Environmental Health Division
1675 W. Garden of the Gods Road
Suite 2044
Colorado Springs, CO 80907
(719) 578-3199 *phone*
(719) 578-3188 *fax*
www.elpasocountyhealth.org

FourSquare at Sterling Ranch East, PUDSP-22-7

Please accept the following comments from El Paso County Public Health regarding the project referenced above:

TRACT H
PROPOSED FULL SPECTRUM
DETENTION POND 16A
488,118 SF
11.21 AC

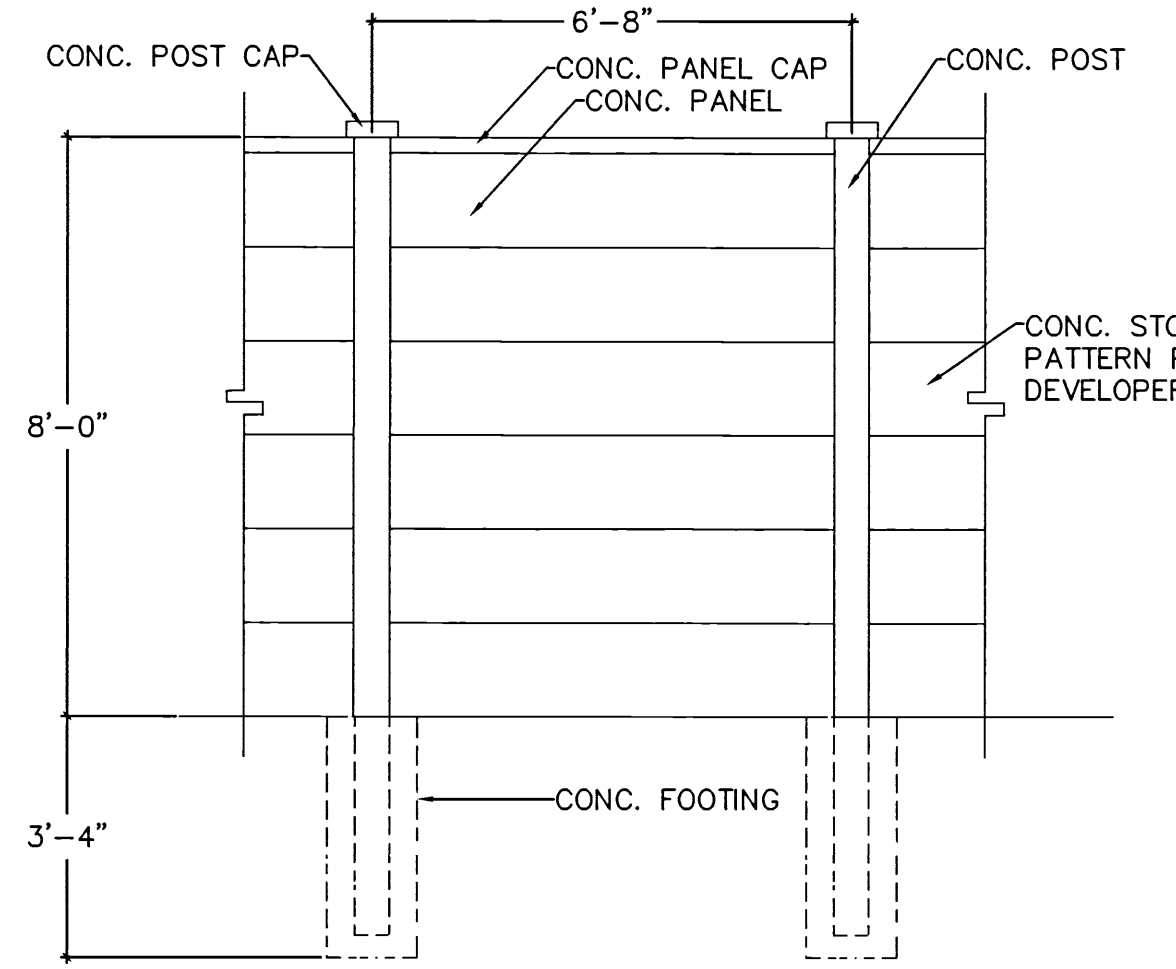
- **The water quality basin in Tract H must have mosquito control responsibilities included as a part of the construction design and maintenance plan to help control mosquito breeding habitat and minimize the potential for West Nile Virus.**
